RFI

RFI #: 161
Date: 6/25/2012
Job: EB-02 Keller Springs Lofts
Phone: 877-777-5115

Subject: Electrical Outlets Moved for Code

**E-2.9**

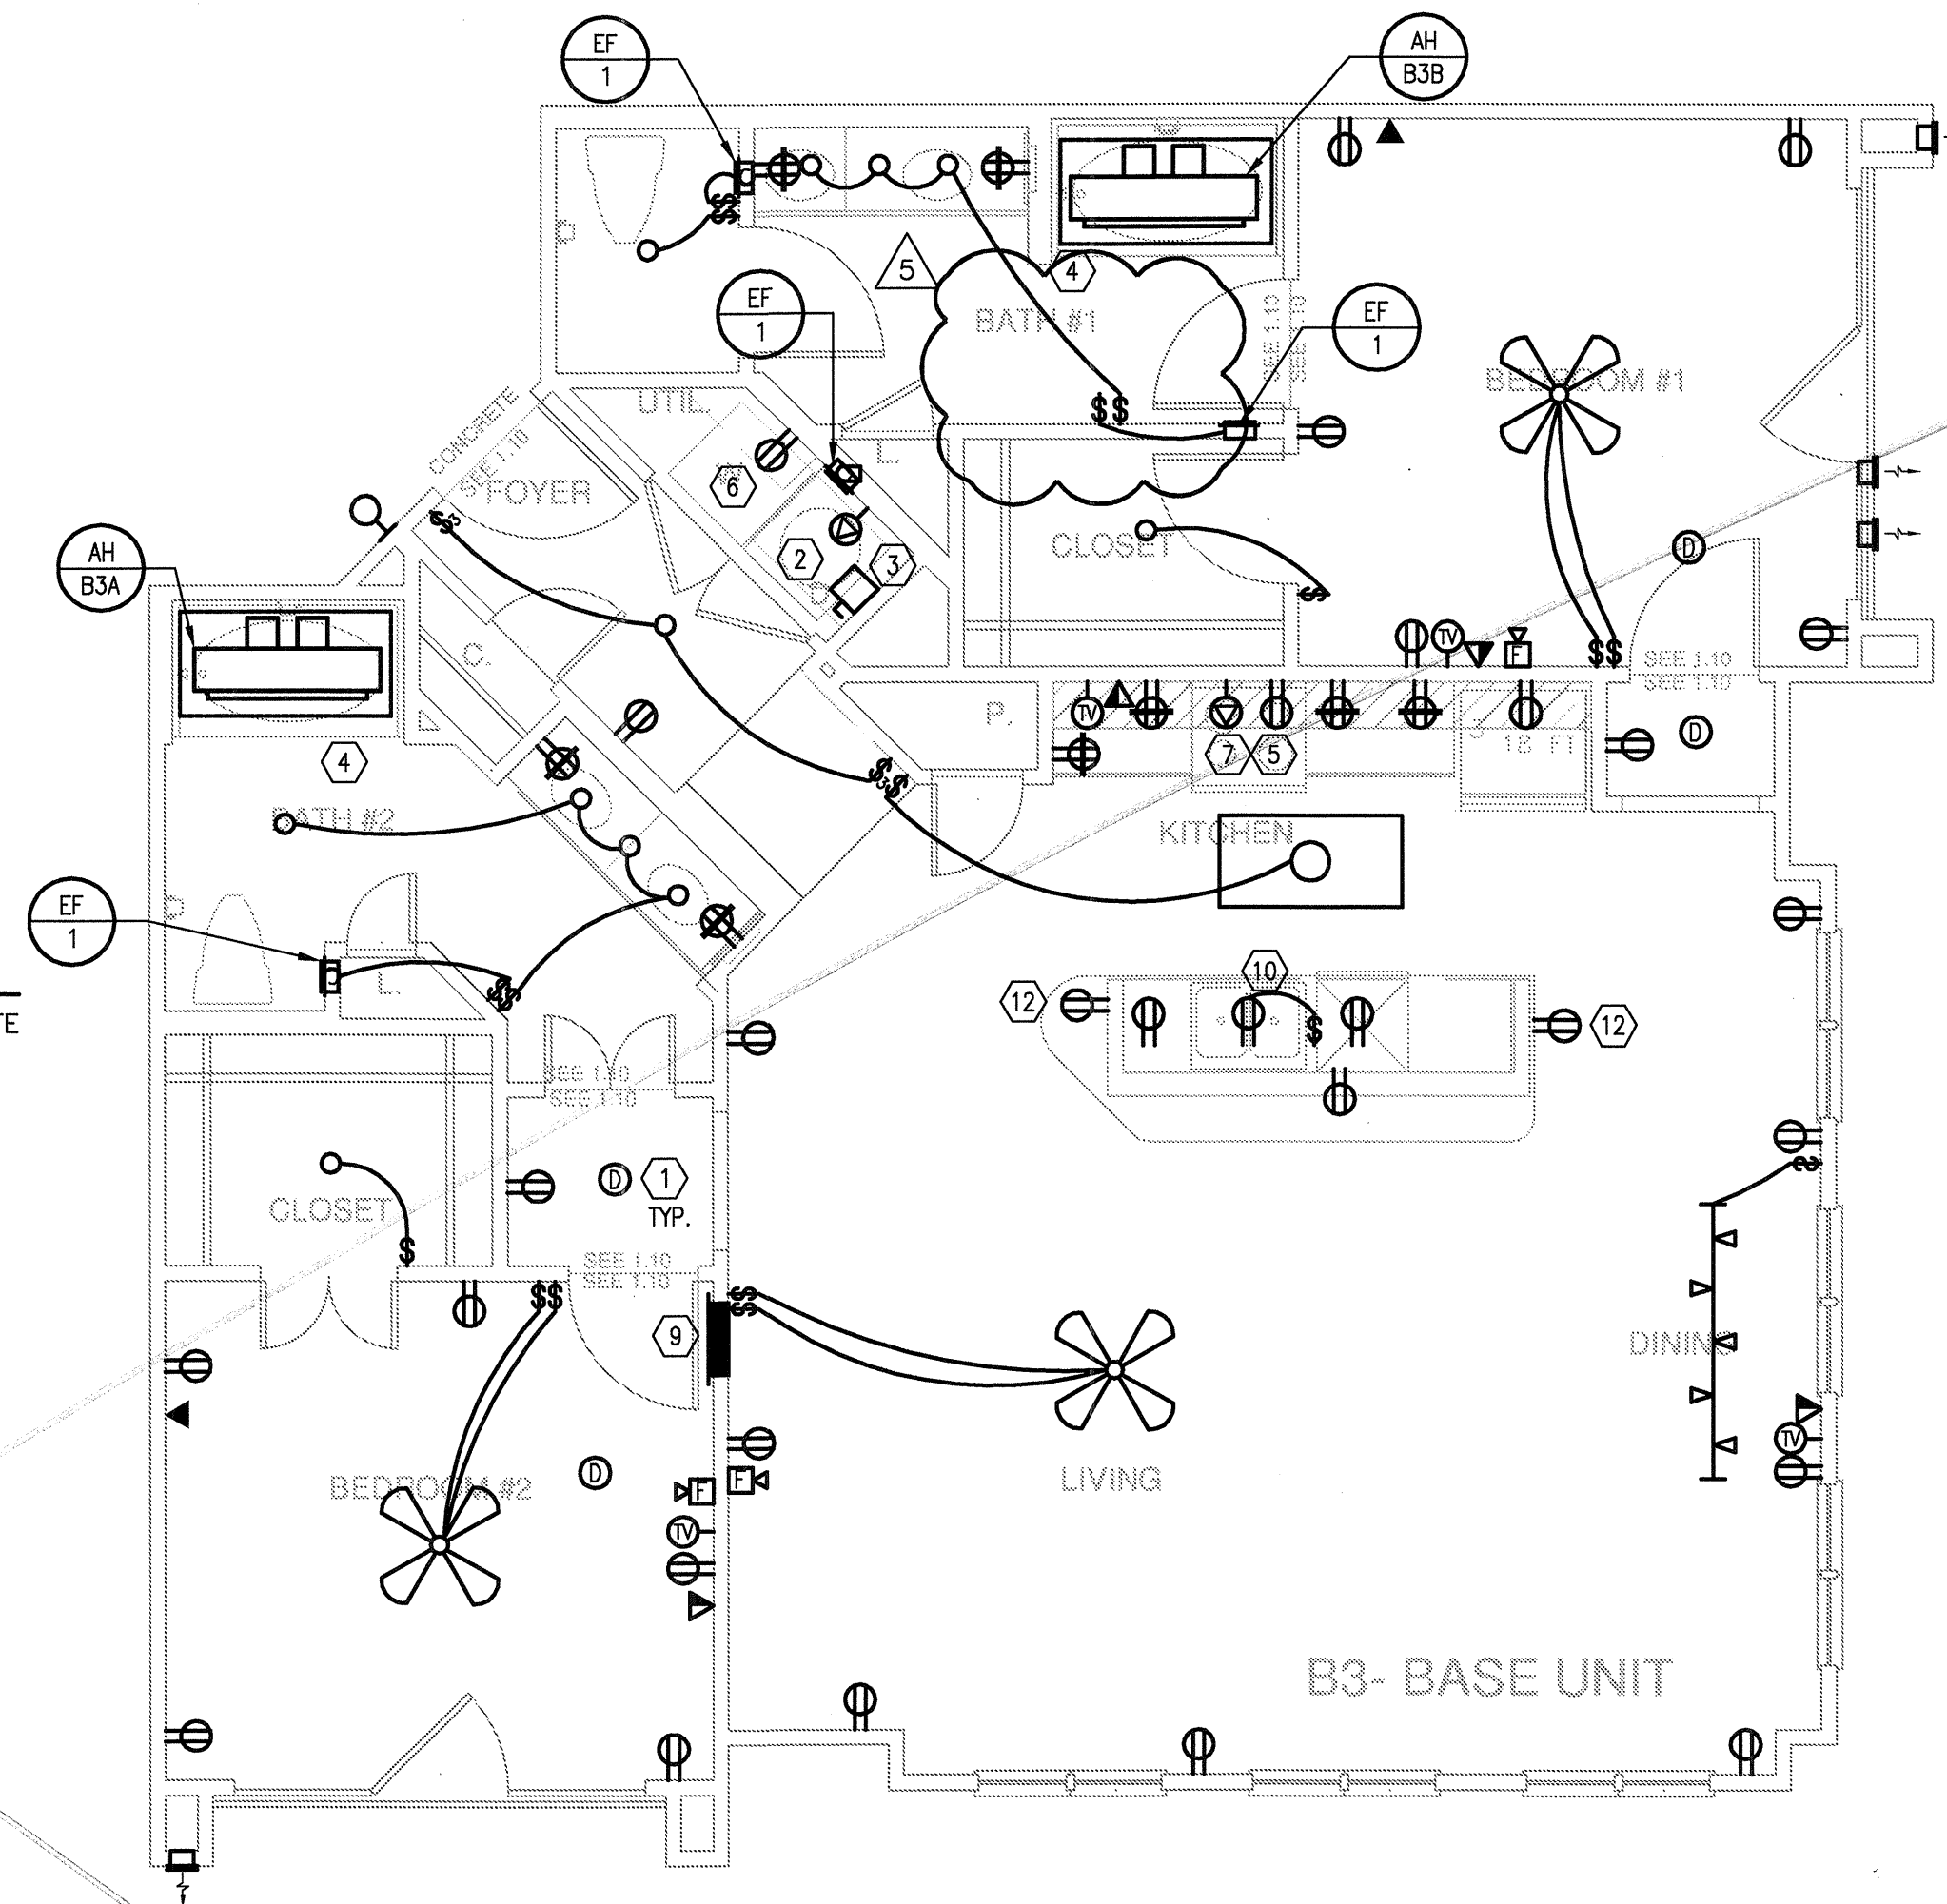
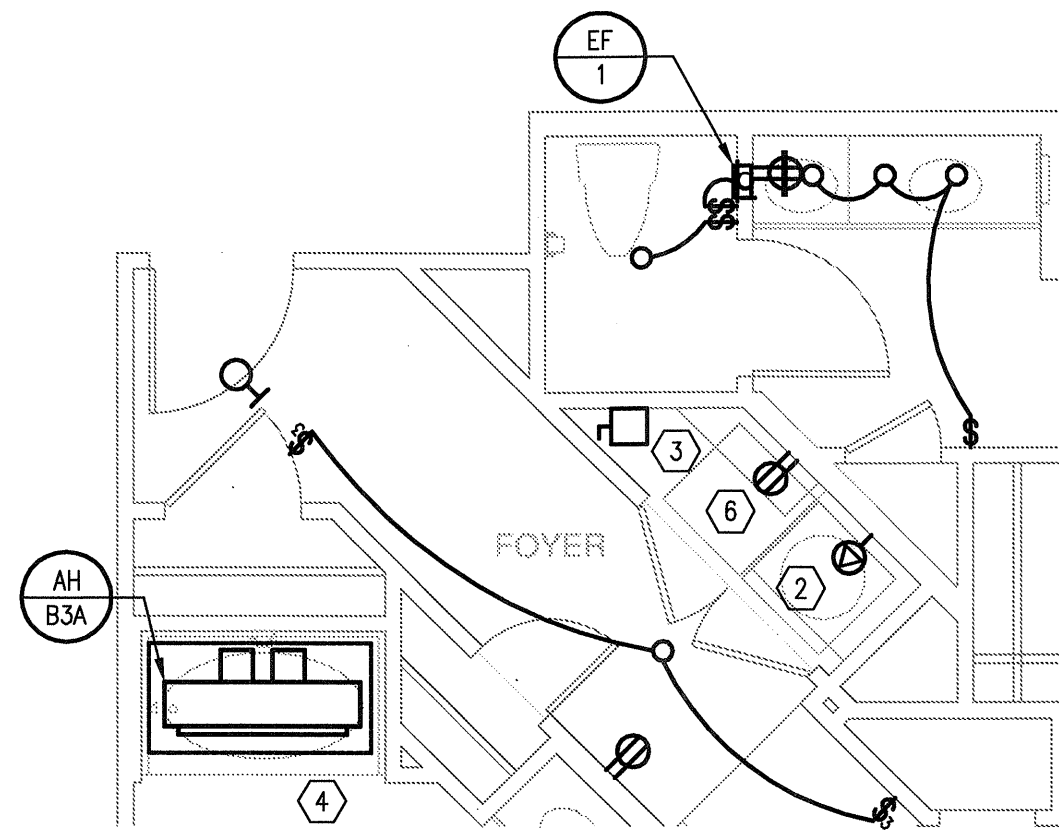
Request: We had an issue at another job where some receptacles needed to be moved in bathrooms due to code. Please check and see if this issue will need to be addressed at this job and revise plans if needed. **Date Required:** 6/26/2012

Reference the attached pdf's showing the correct outlet locations.
